## HERITAGE IMPACT ASSESSMENT ADDENDUM

**Project:** 593, 601, 603 Laurier Avenue West  
Ottawa, ON  
K1R 6K9

**Re:** HIA Addendum

**Date:** 2025-Oct-01

#### FLOOR PLAN LEVEL 5 - 6

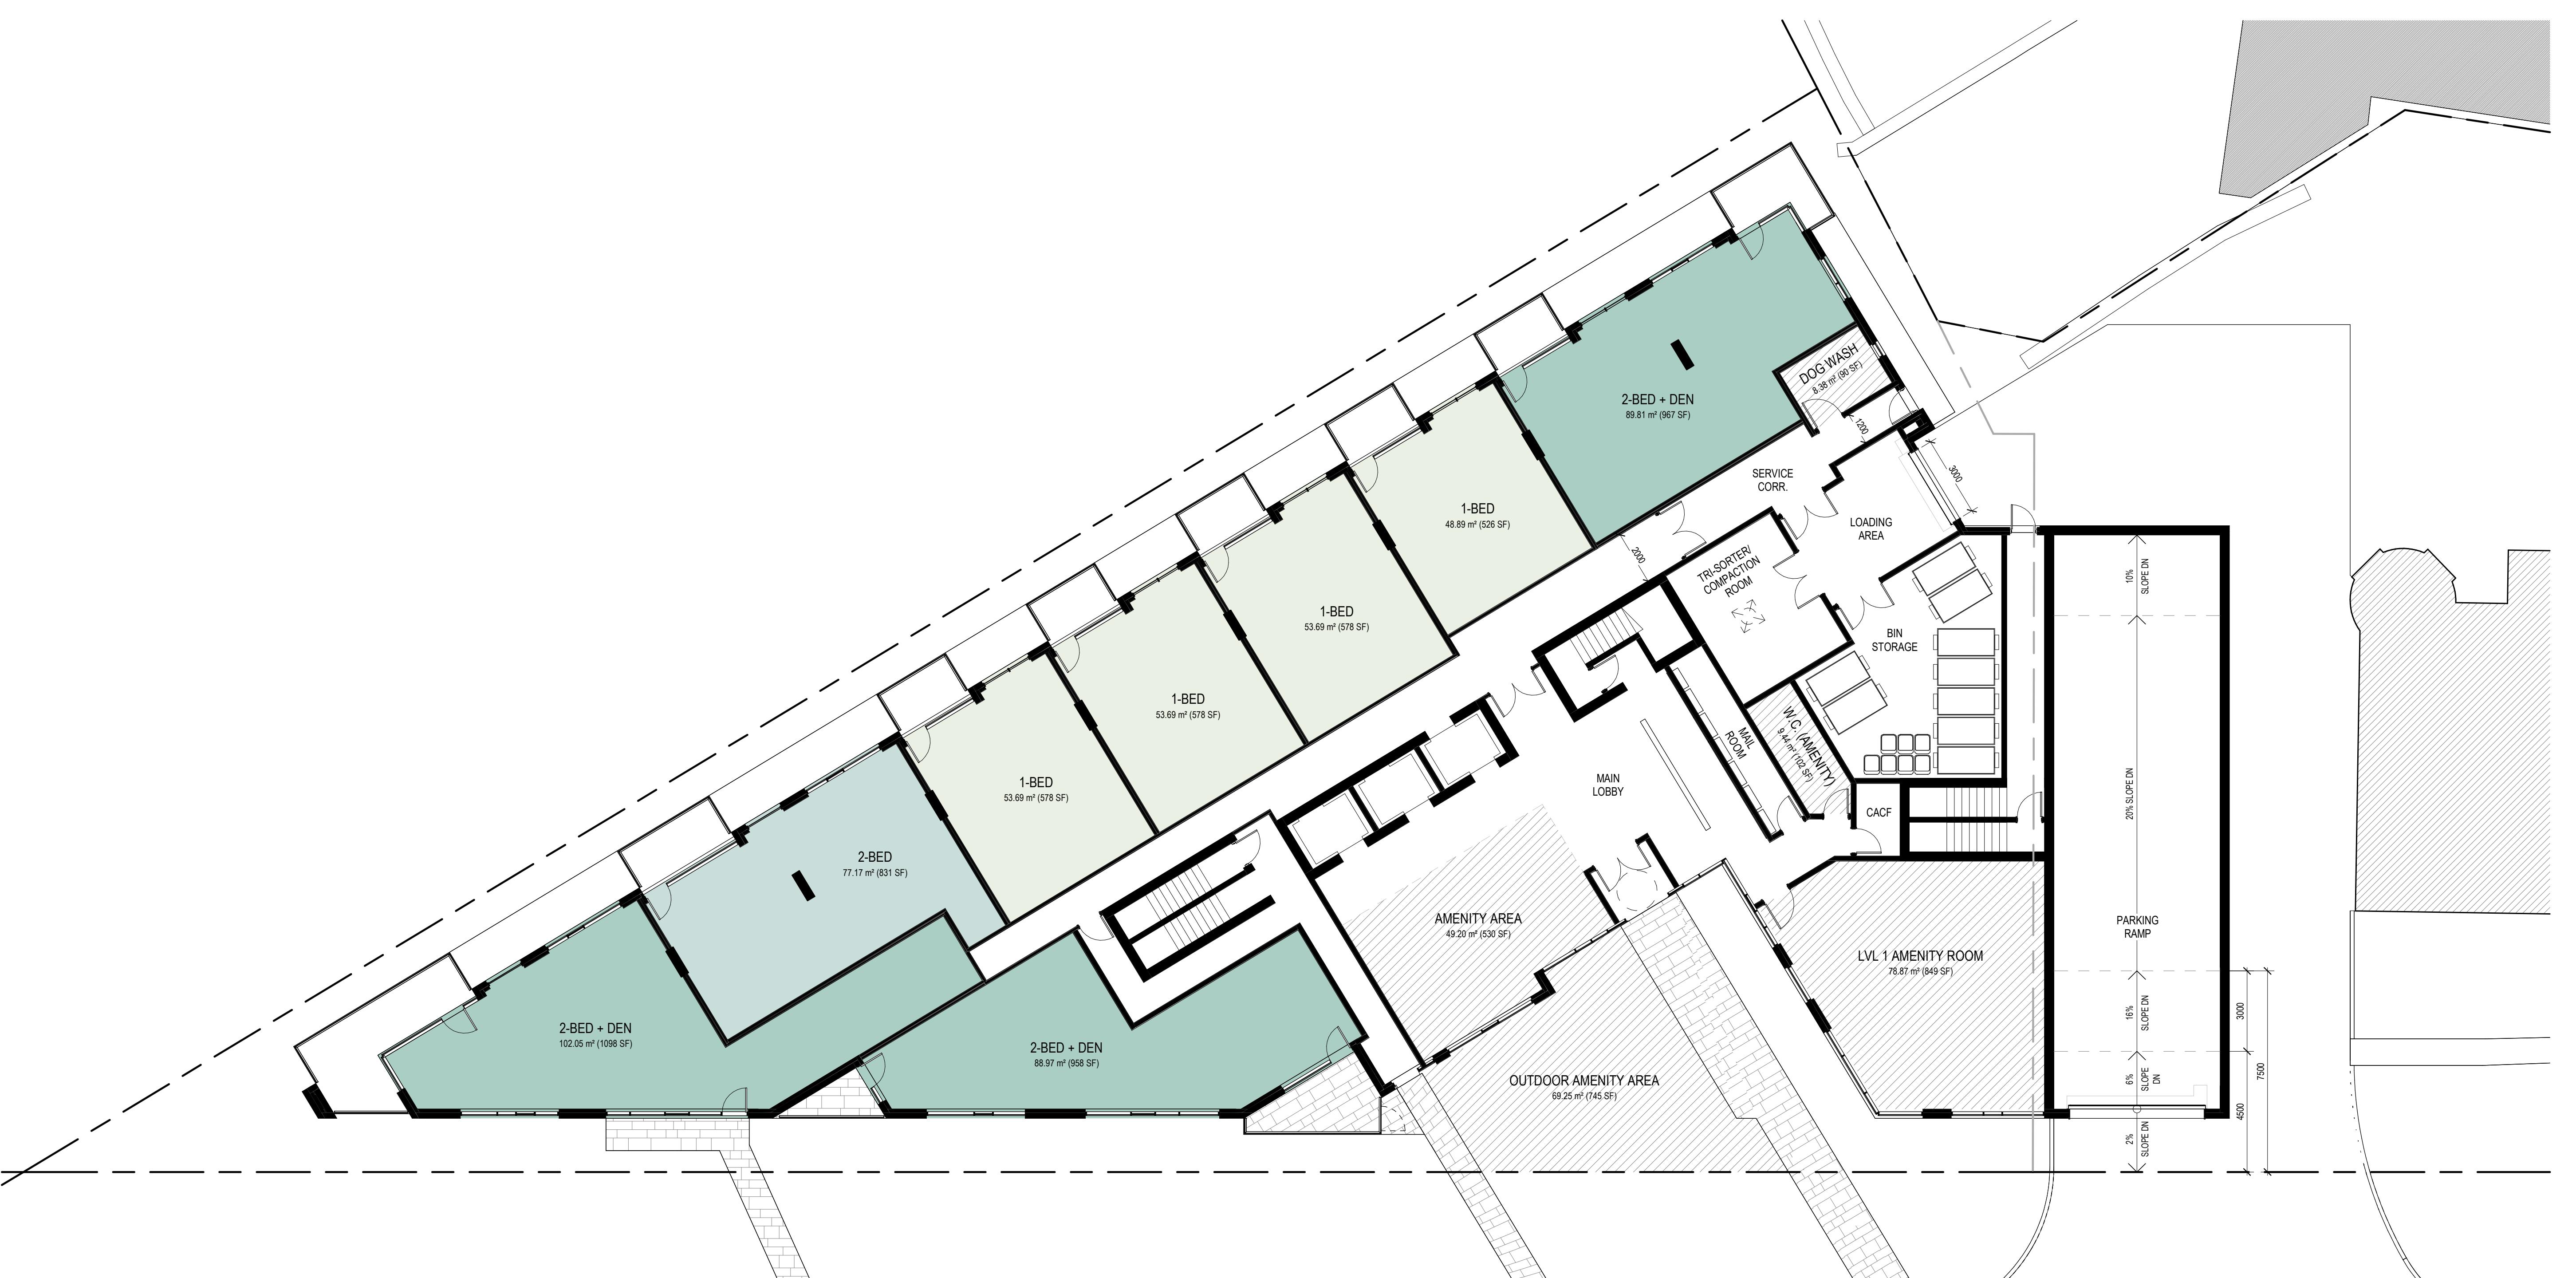
- The 5<sup>th</sup> and 6<sup>th</sup> levels on the east wing of the new building, next to the heritage building, have been updated to show inset balconies, replacing the previously proposed cantilevered balconies. This change simplifies the building massing at this location and increases the visual setback of these two floors. This is expected to have minimal impact on the heritage building.

- The building has been minimally elevated, resulting in a slightly taller 6-storey wing next to the heritage building. This change has minimal impact on the new building’s relationship with the heritage building.

#### FLOOR PLAN LEVEL 7

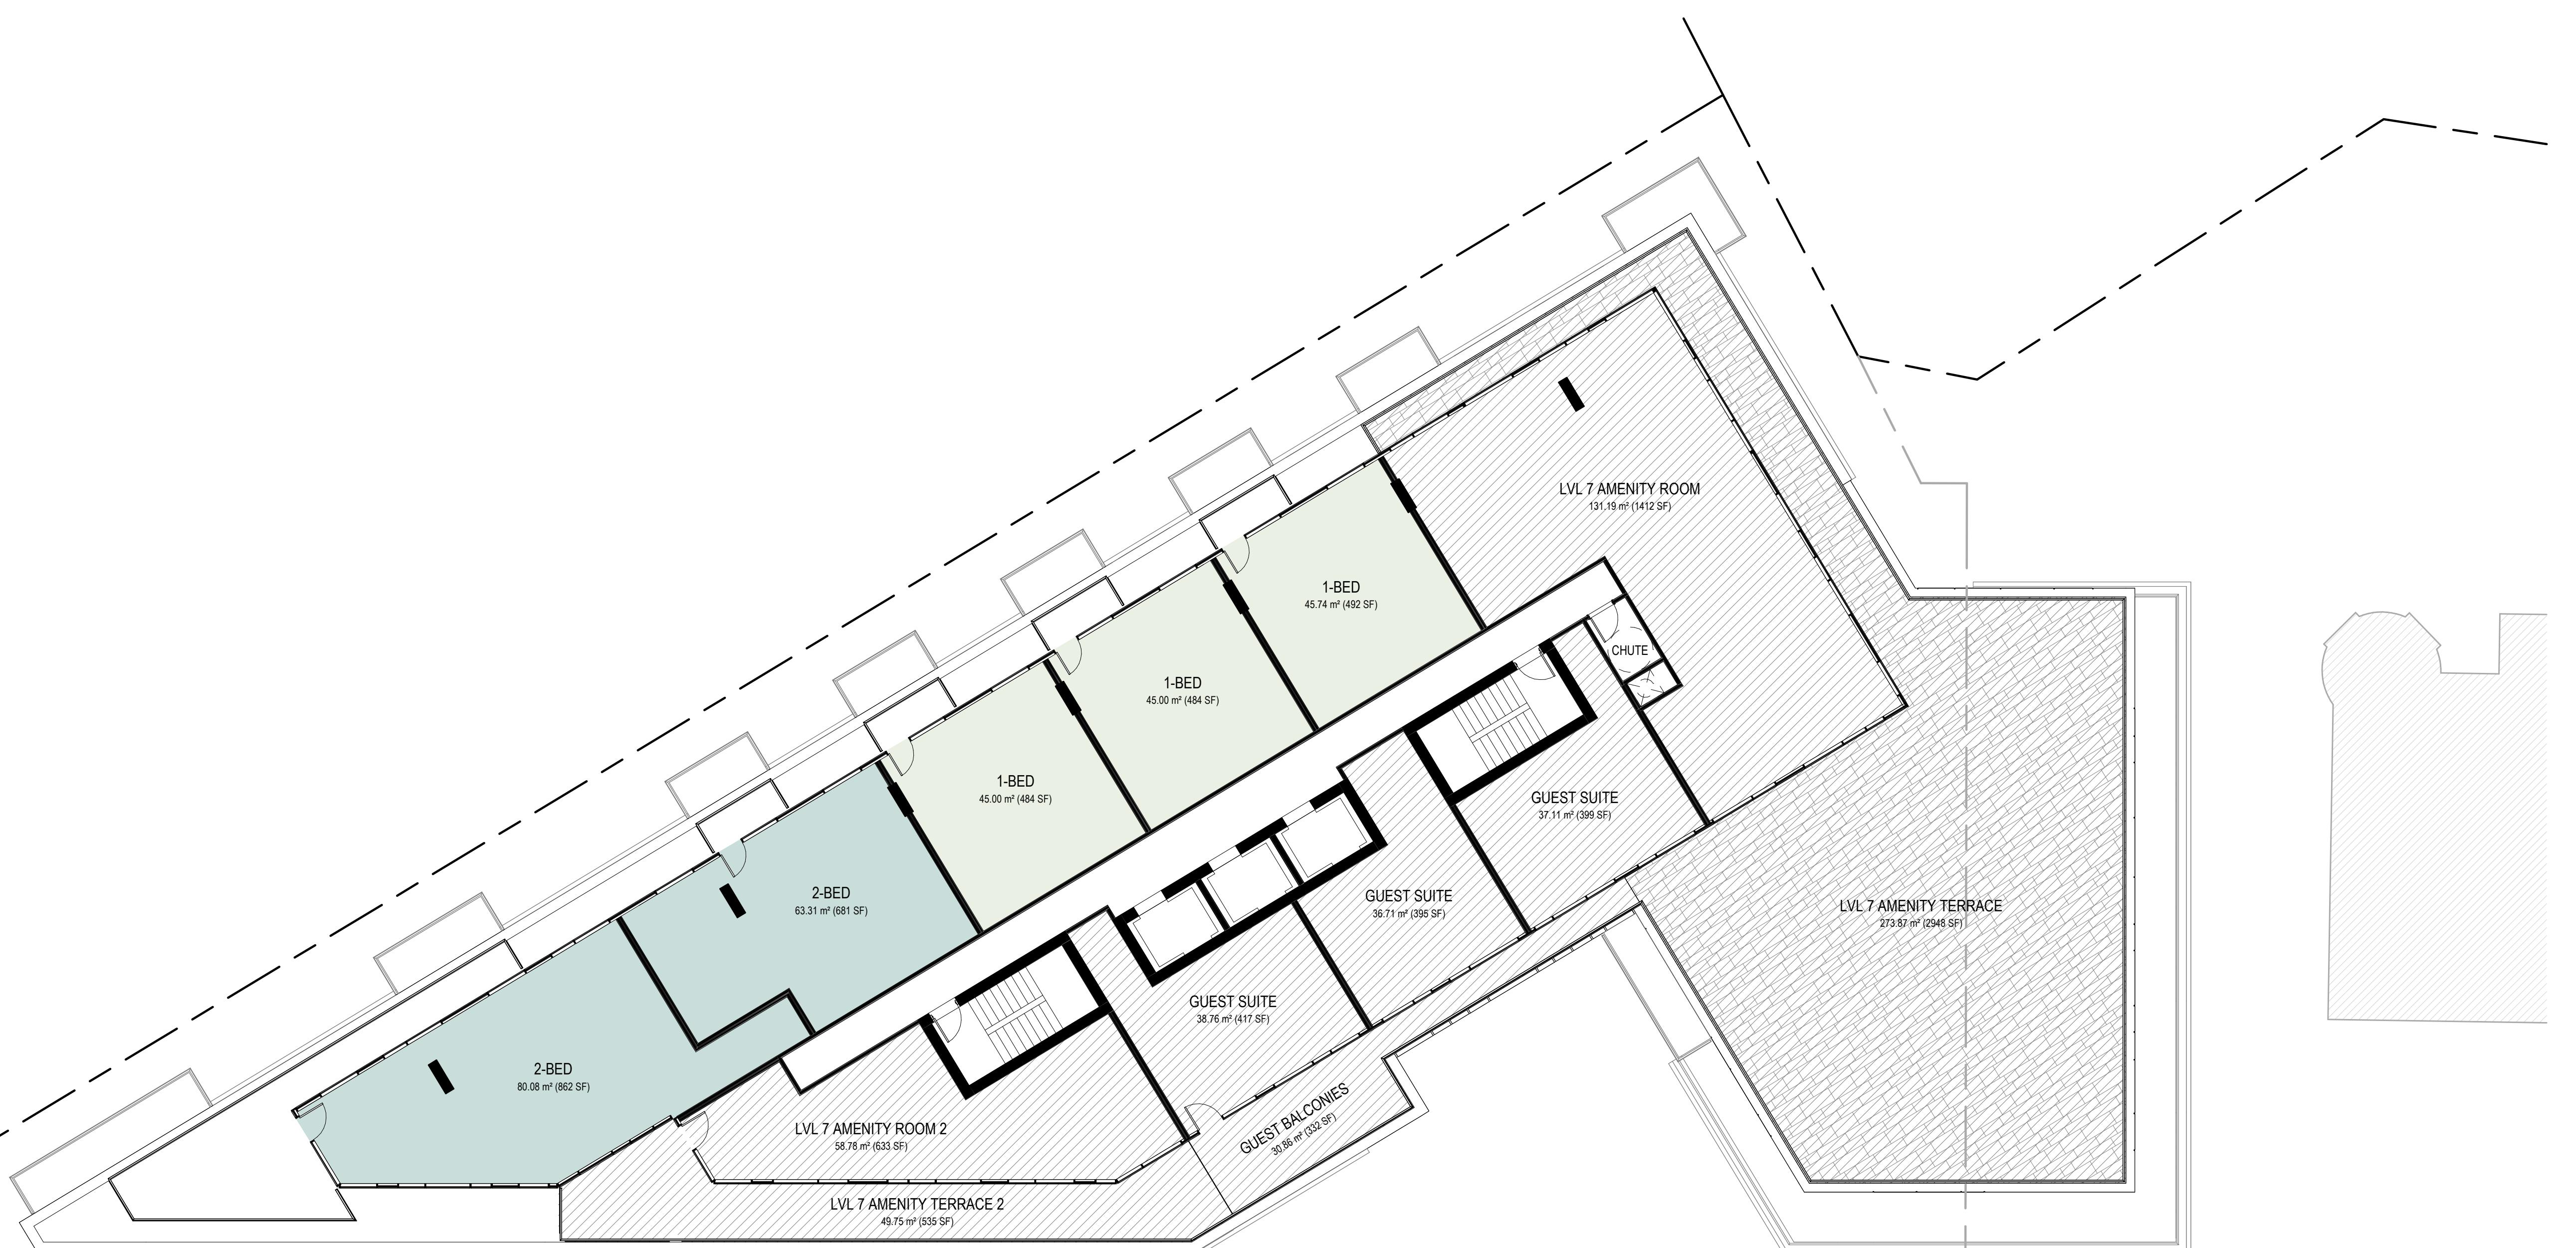
- Minor adjustments have been made to the tower’s articulation, including the extension of levels 1 to 6 at the south corner, which increases the street frontage; the reduced setback of the west façade at level 7; and the removal of the inset balconies on the east façade from level 8 to 28. These changes have minimal impact, as the visual relationship between the tower and the heritage building remains largely unchanged.
